PLANNING APPLICATION FORM - CONTINUATION SHEET

QUESTION 6. Condition(s) – Removal

Condition 2

Job No.	Draw No.	Stage	Revision
031601	PD03	Planning	P5

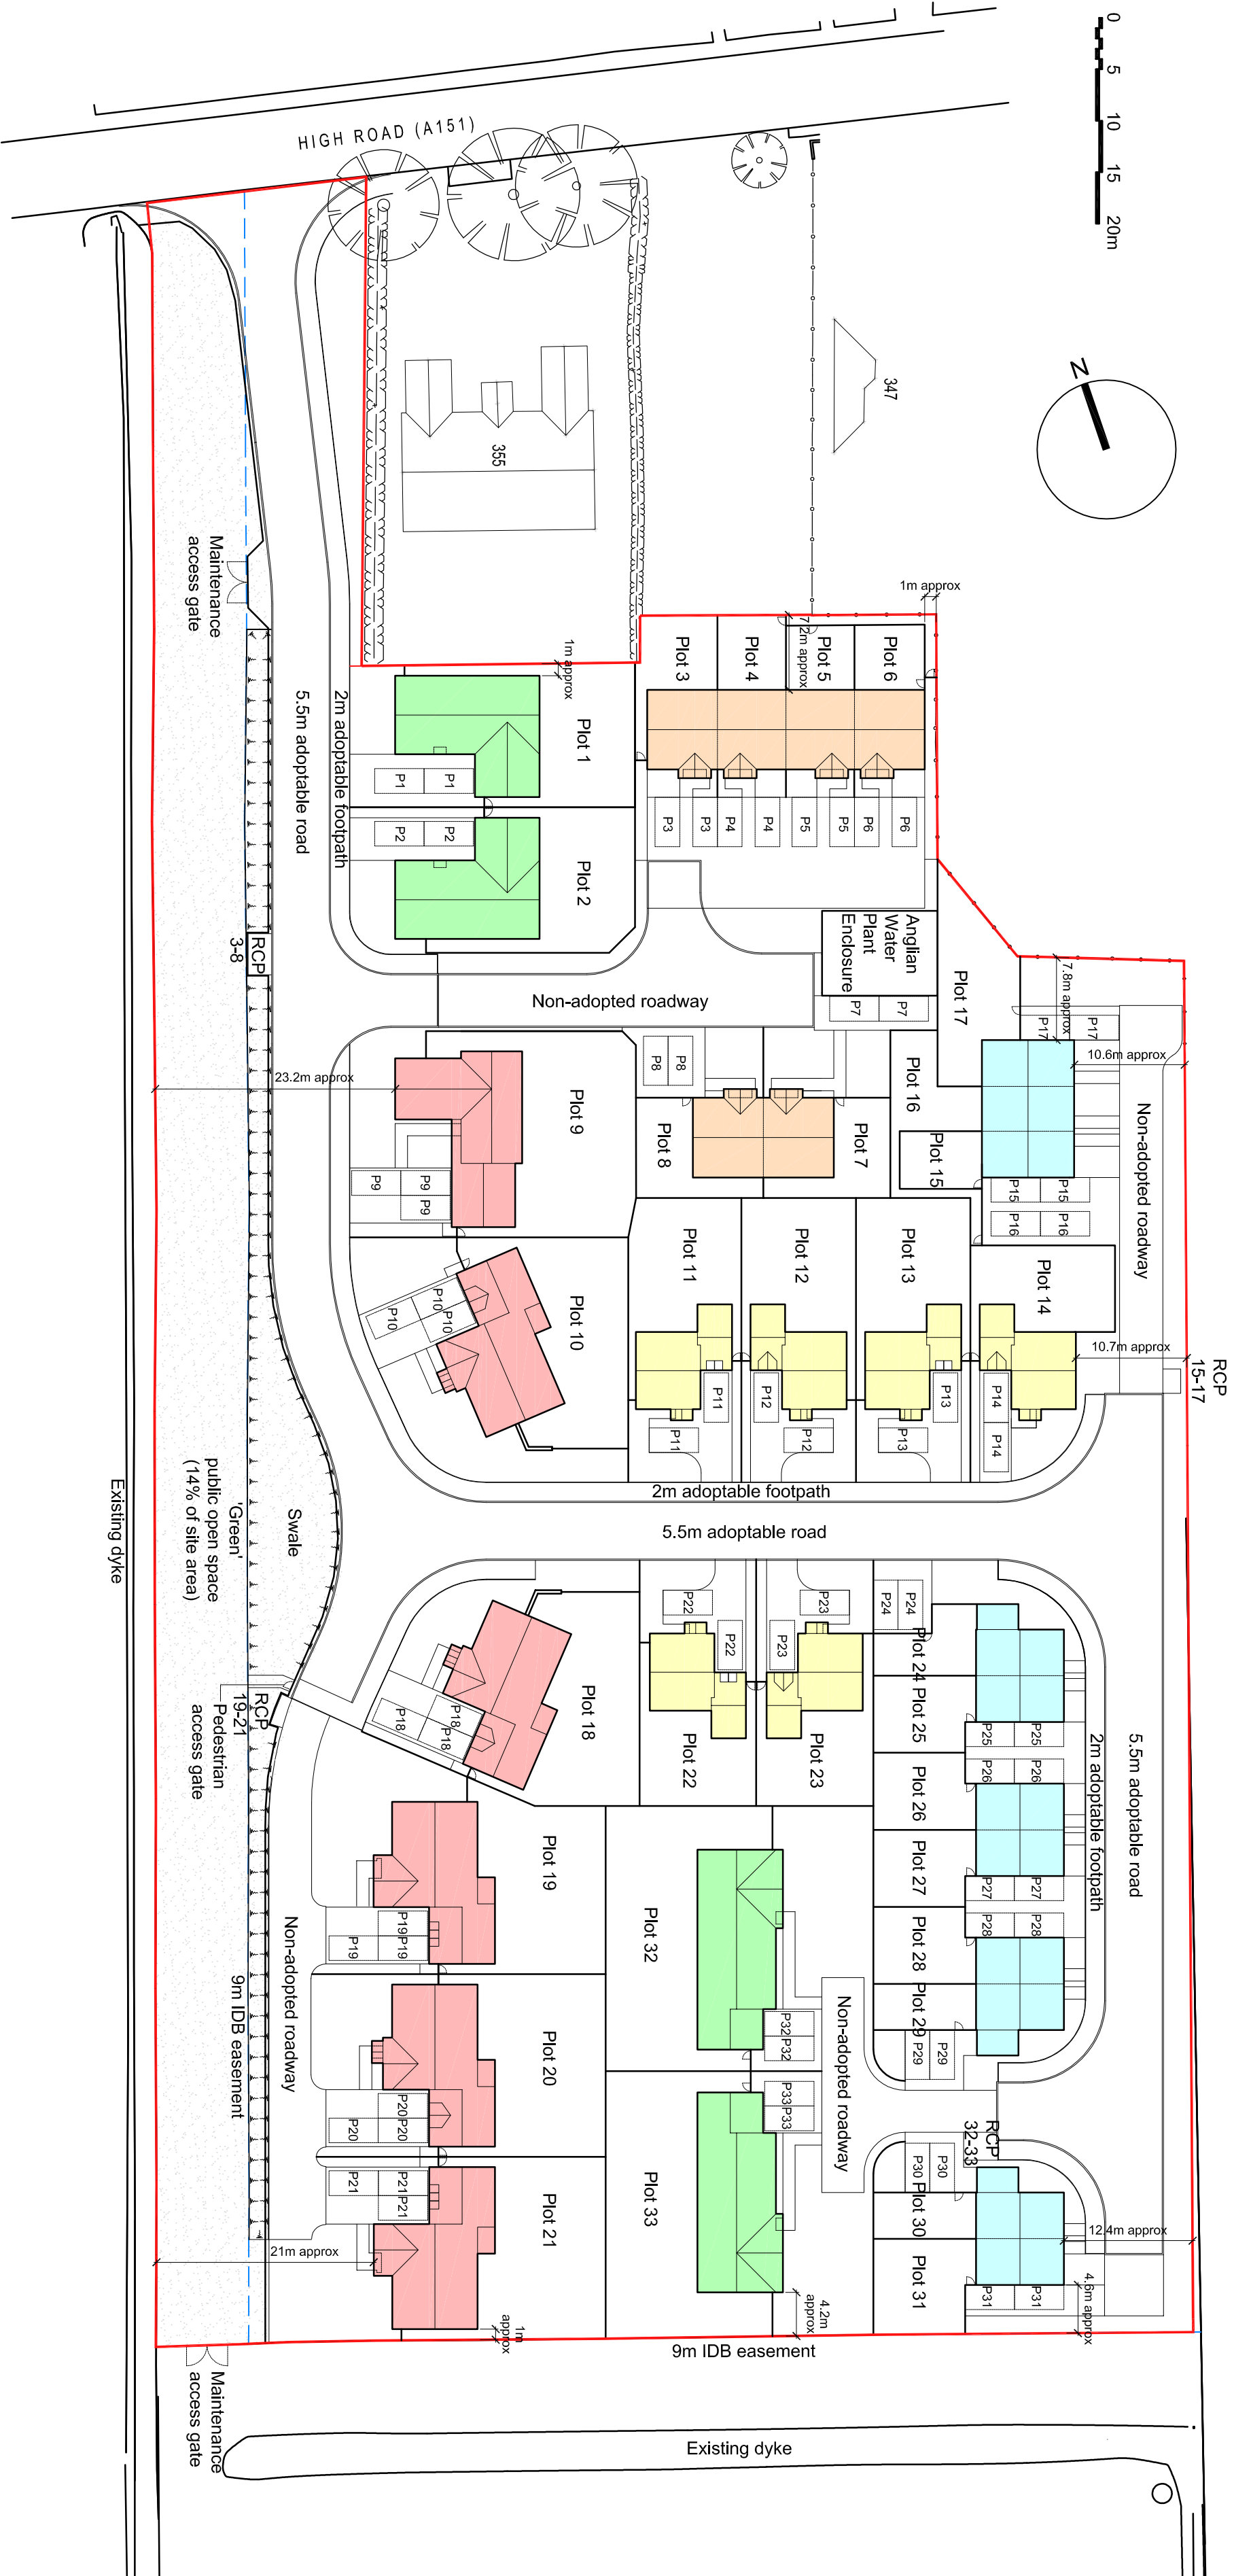
Extend the site boundary up to the 9m IDB easement.

Plot 7 parking relocated.

Plot 16 parking relocated to be adjacent to plot 15 parking (reduced rear garden to plot 14).

Plots 15-17 moved southwards slightly to allow Anglian Water easement for drainage pipes.

Plot 17 parking changed to tandem parking.

Adoptable roadway serving plots 3-8 & 16 changed to non-adopted roadway and will serve just plots 3-8. Refuse collection point added.

Plots 32 & 33 amended so that plot 32 is same bungalow type as plot 33, and both plots widened.

Adoptable footpaths widened to 2m (required by LCC).

Some garden walls cut back/omitted.

PD03, PD04 & PD05 are changed to show revised site layout.

Client:	Haycroft Homes Ltd								
Drawn:	AMW	Checked:	AMW	Date:	22.04.16	Scale:	1:100	Page Size:	A1
Job No.:	031601	Draw No.:	PD06	Stage:	Planning	Revision:	P2

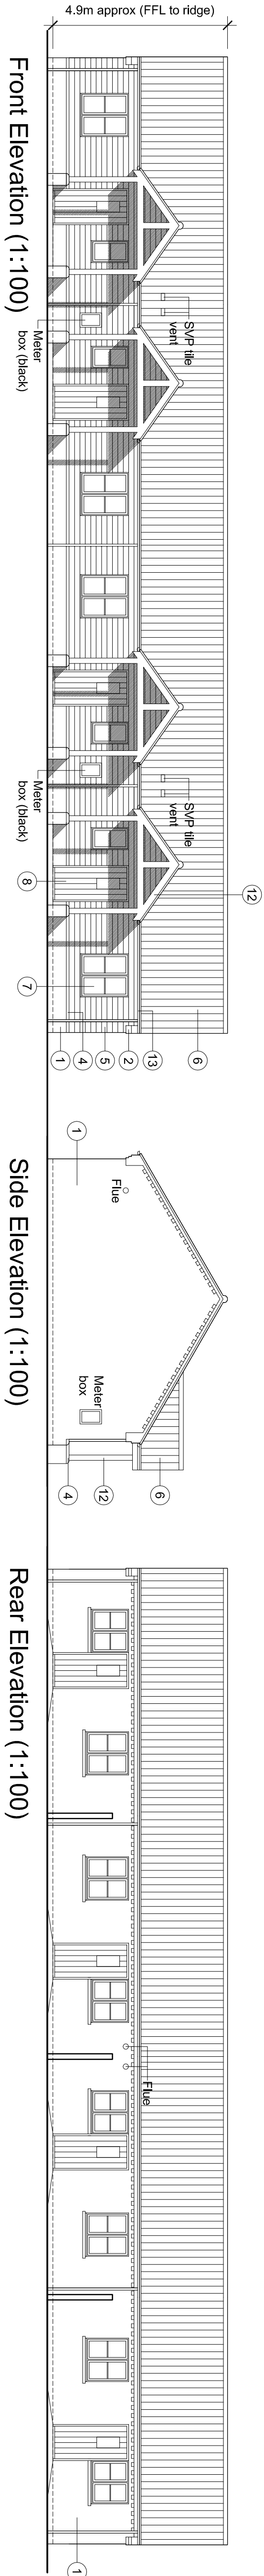
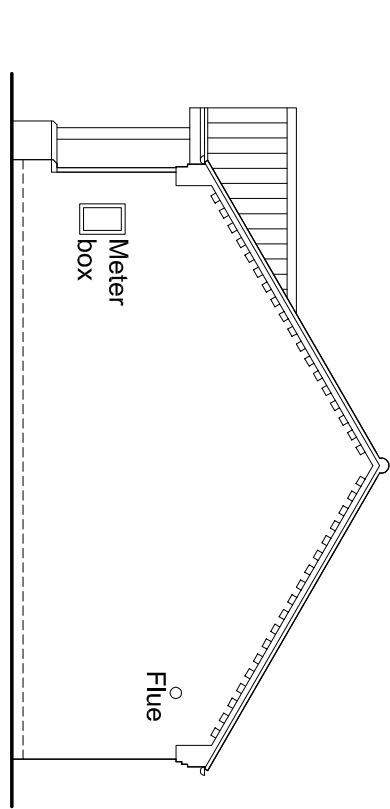
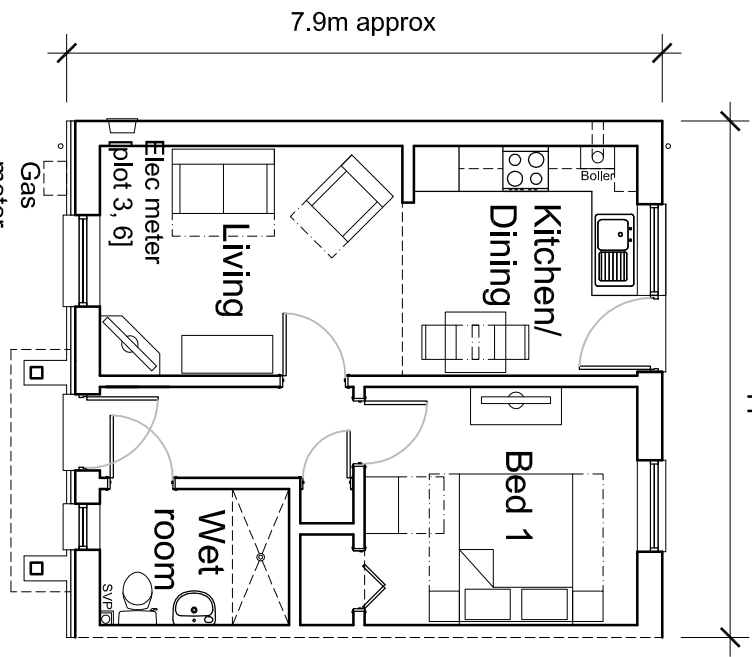
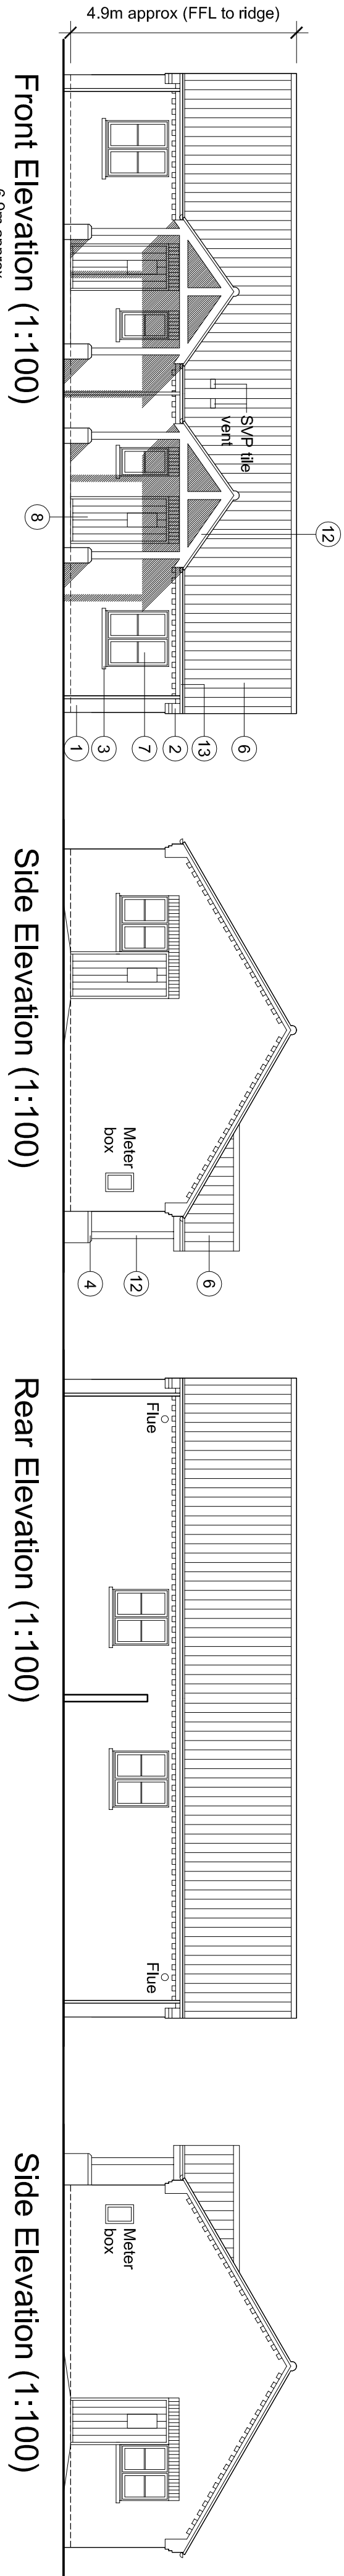
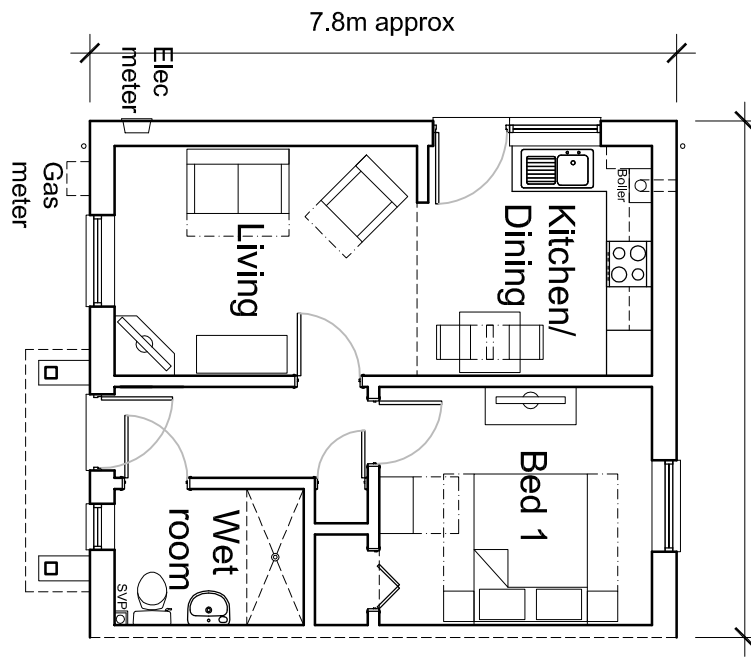
PD06, PD07, PD08, PD09, PD10 & PD11 are changed to show the addition of meter boxes, gas flues and soil vent pipes. In addition drawing PD08 is changed to show widened properties. In addition drawing PD11 is changed to show revision to plot 32 to be same bungalow type as plot 33.
